To Caroline Callow  
From Growth Lancashire  
Subject Conservation Comments  
Date 2 November 2023

Ref: 2023/0491

**Proposal:** Replacement of an existing window on rear elevation with a double glazed door.

**Site Address:** Yates Cottages, Lumb Lane, Whitewell  
Bottom, Rossendale BB4 9RW

proposed formation of enlarged structural opening and installation of patio door at

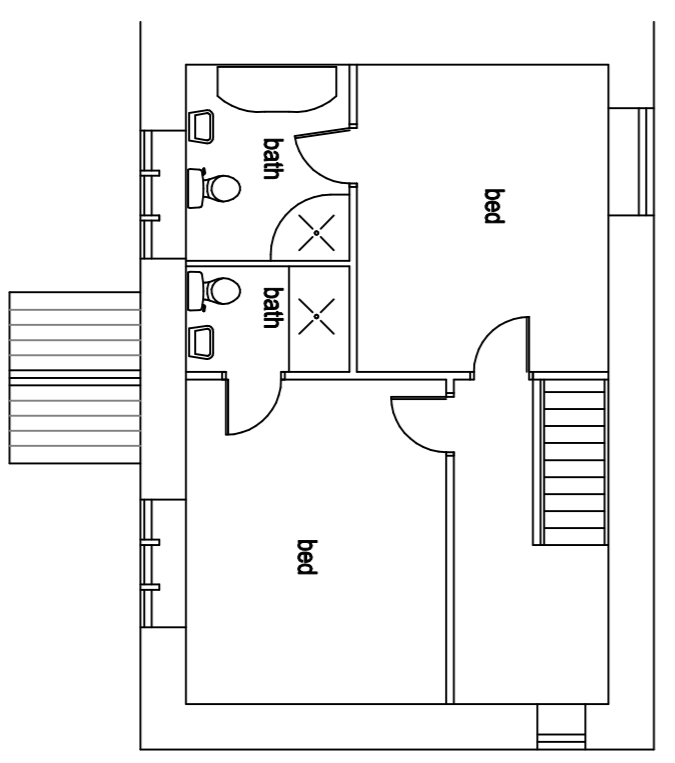
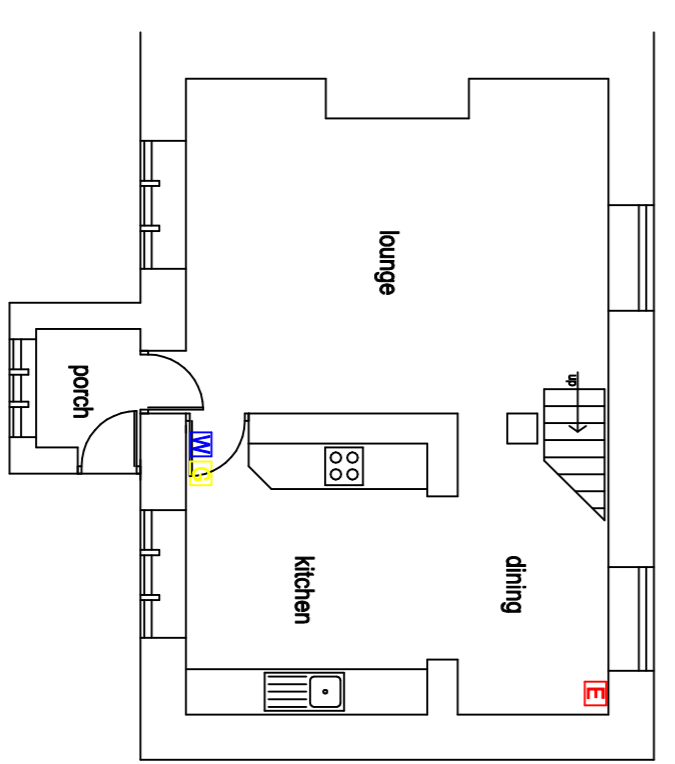
The proposal is for the alteration of an existing window at the rear of number 5, to be enlarged and replaced with a glazed pair of timber framed doors.

The cottages are a pair of late C18 stone cottages with a single depth floor plan. Much of their significance is defined by the simple architectural form and external appearance. The alteration to create a new doorway, will result in some, small loss of existing stonework to enlarge the opening.

I note that this alteration is similar to the creation of a door/window at the rear of No.3, which was part of various alterations granted LBC under application 2021/0093 two years ago. Whilst I would prefer to see perhaps a normal sized single (glazed) door I recognise that the enlarged opening utilises the width of the existing window.

Whilst a small panel of existing walling will be lost in creating the doors I think given the recent history with the approved alteration at No.3, when viewed across the elevation the change in appearance will be minor work and not result in any discernible loss of significance to the pair of cottages.

I would therefore view this alteration as having a neutral effect on the listed building and in summary consider the proposals to be acceptable.
